Ribble Valley Borough Council
Housing & Development Control

Application no: **3/2023/0243**

Address: **19 Eastmoor Drive Clitheroe BB7 1LG**

Proposal: **Removal of existing garage and car port and construction of a single storey side and rear extension including garage to the side.**

Client: Mr Chris Mercer		
Project: Proposed Extension 19 Eastmoor Drive Clitheroe		
Dwg title: Proposed Ground Floor Plan		
Scale @ A3: 1:50	Date: 01.03.23	Drawn by: PD
Drawing no. 1435 - 05	Rev. -

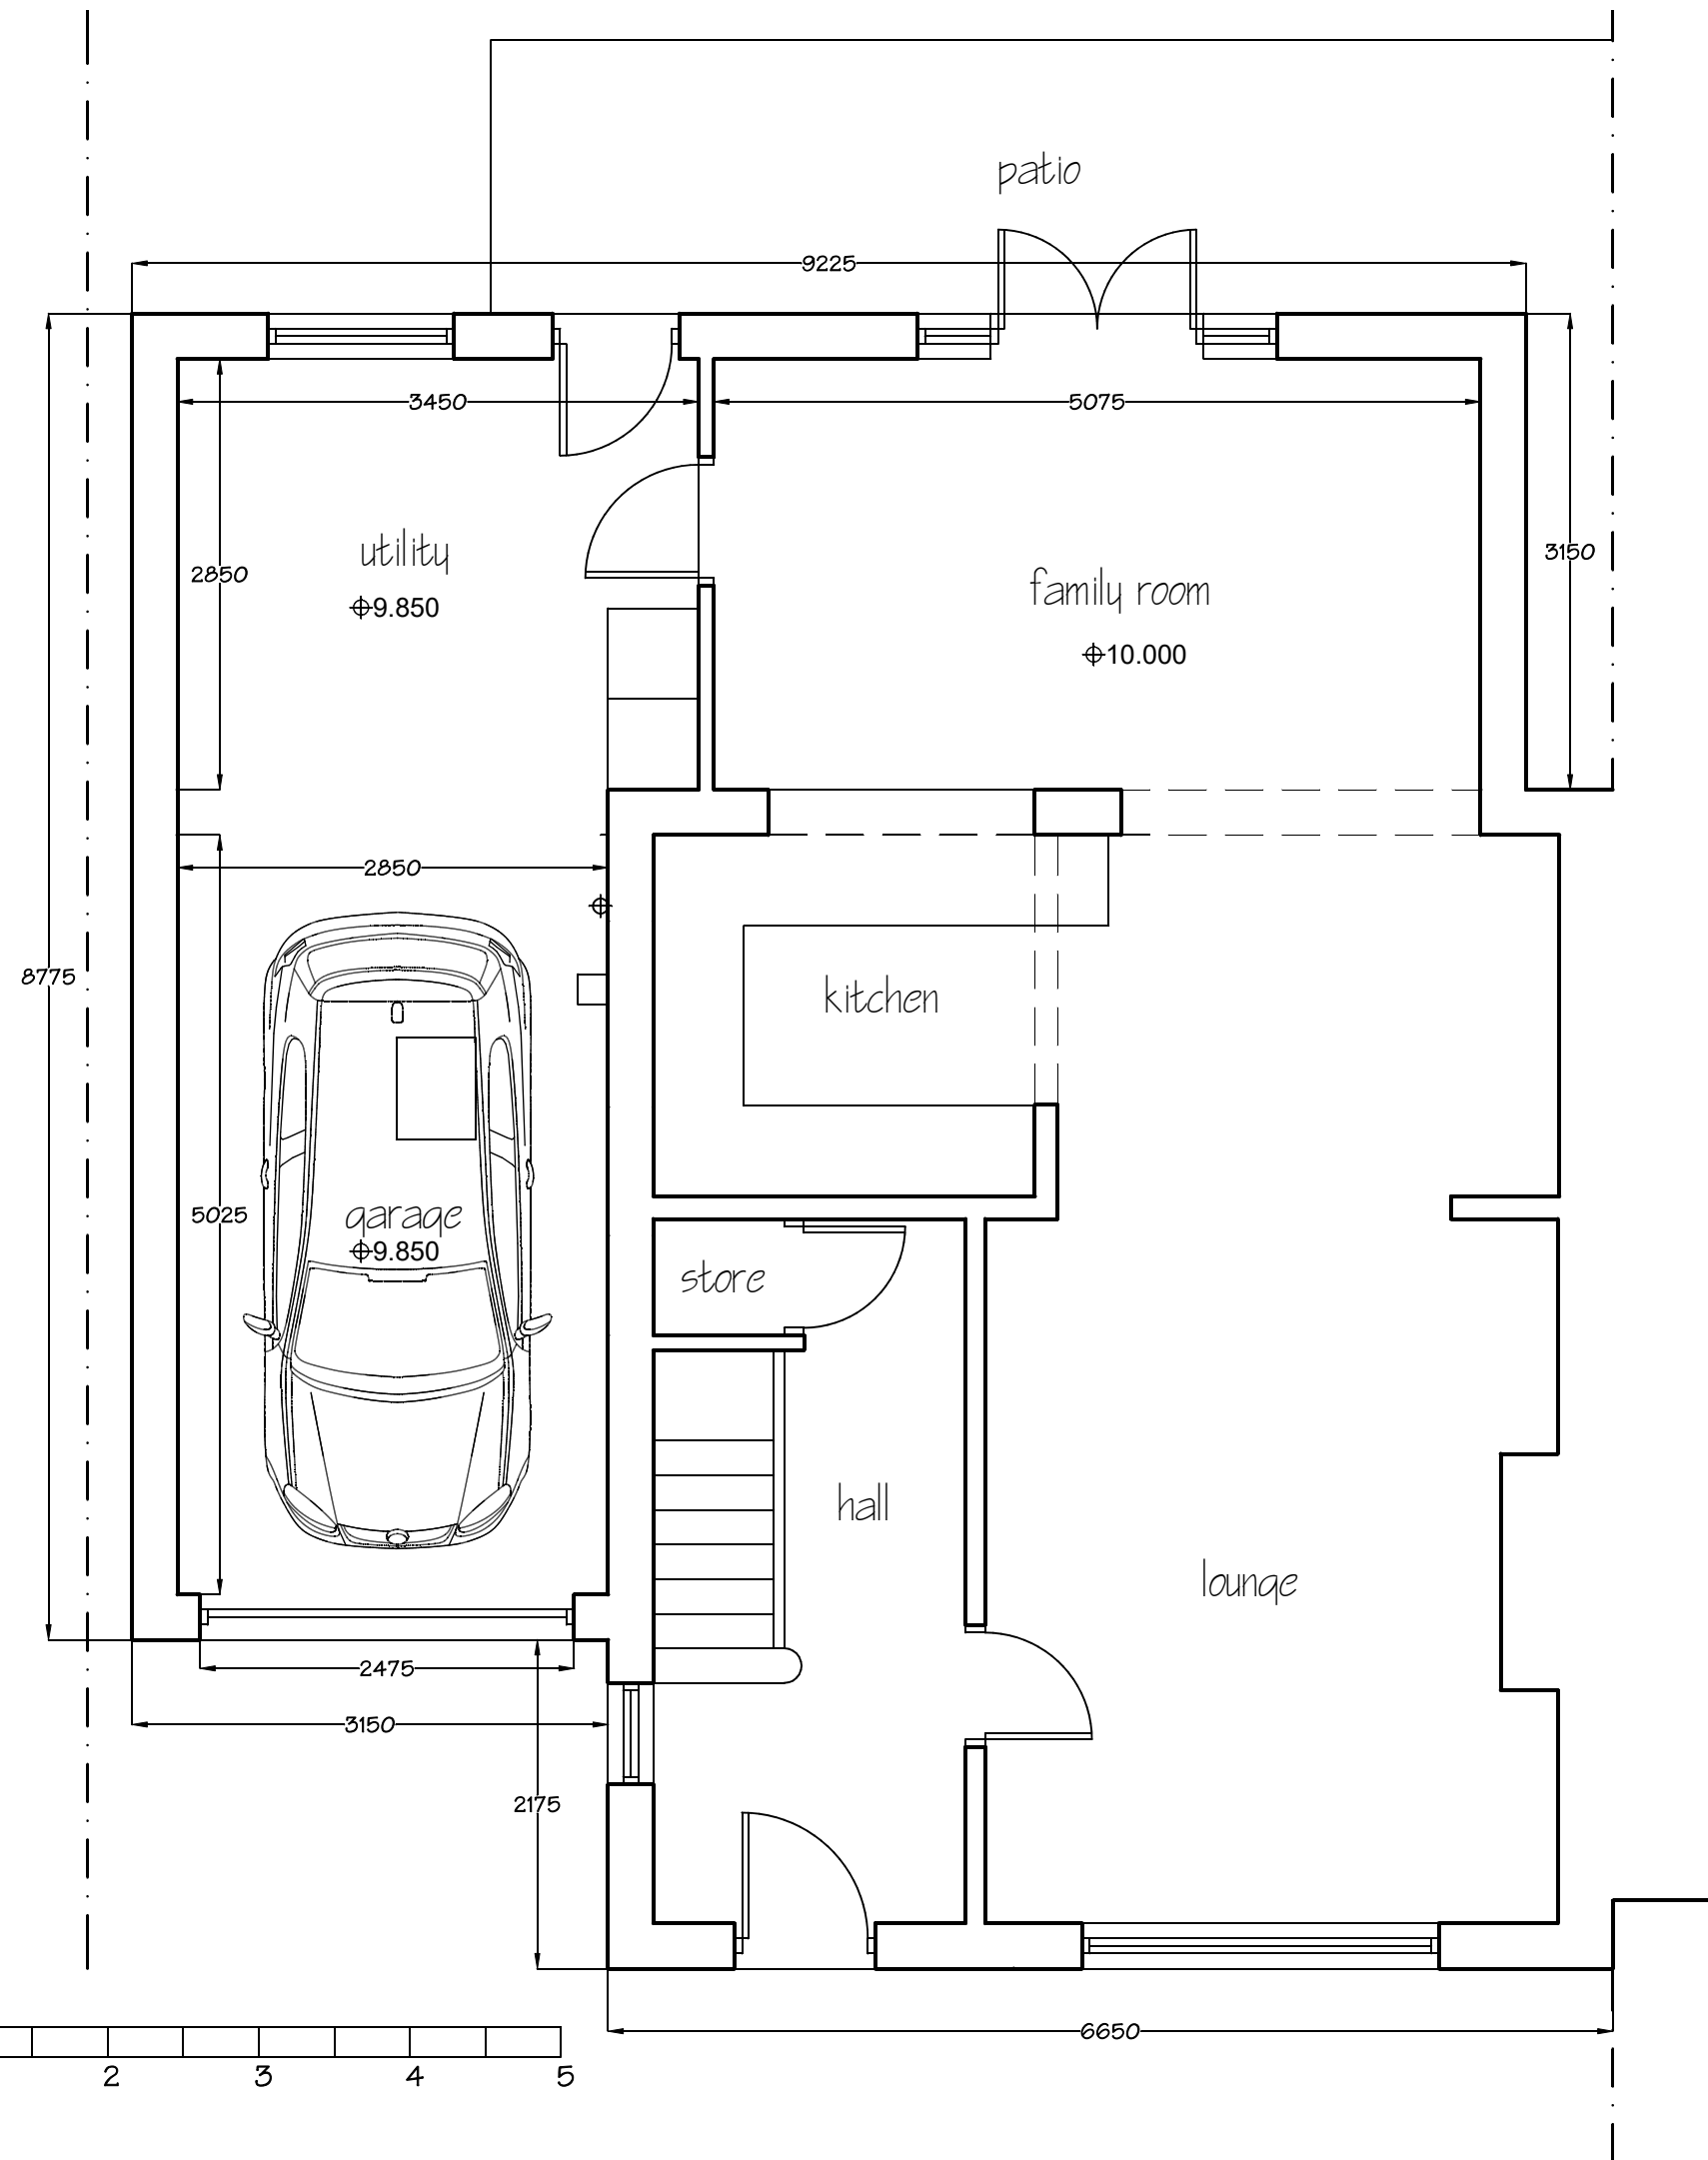
The LHA are unable to accept the proposed garage, as shown on PD drawing number 1435-05 titled "Proposed Ground Floor Plan," providing a car parking space because the internal dimensions, which are 5.025m x 2.85m do not comply with the LHAs guidance, which requires the internal dimensions to be 6m x 3m when a garage is providing a car parking space.

Therefore, to ensure that 2 car parking spaces are continued to be provided at the site following the proposal, the LHA will request either the proposed garage is extended to the required dimensions so that it can provide a car parking space, or the existing driveway is extended to provide the additional space. Either alternative should be shown on a revised plan.

Client: Mr Chris Mercer		
Project: Proposed Extension 19 Eastmoor Drive Clitheroe		
Dwg title: Proposed Site Plan		
Scale @ A4: 1:200	Date: 22.03.23	Drawn by: PD
Drawing no. 1435 - 102	Rev. -

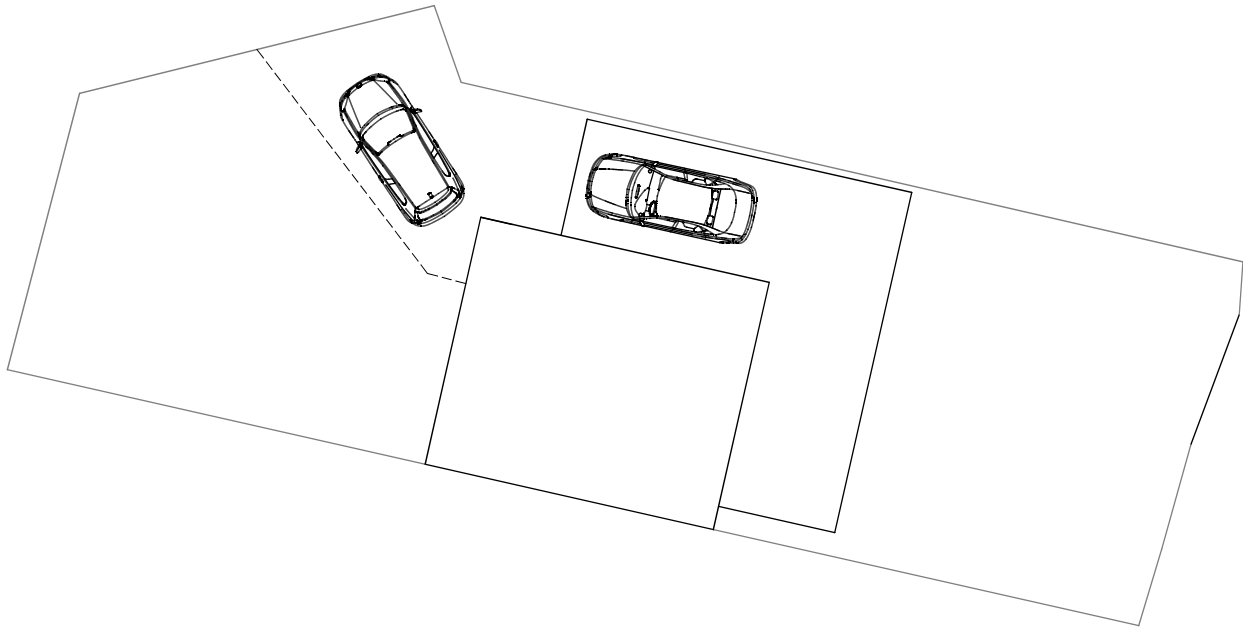
While the number of bedrooms at the site will remain as existing, the parking arrangements at the site will change as a result. This is because the LHA have reviewed PD drawing number 1435-05 titled "Proposed Ground Floor Plan" and PD drawing number 1435-102 titled "Proposed Site Plan" and are aware that the site can only provide one car parking space which complies with the LHAs guidance, with this being provided on the existing driveway.
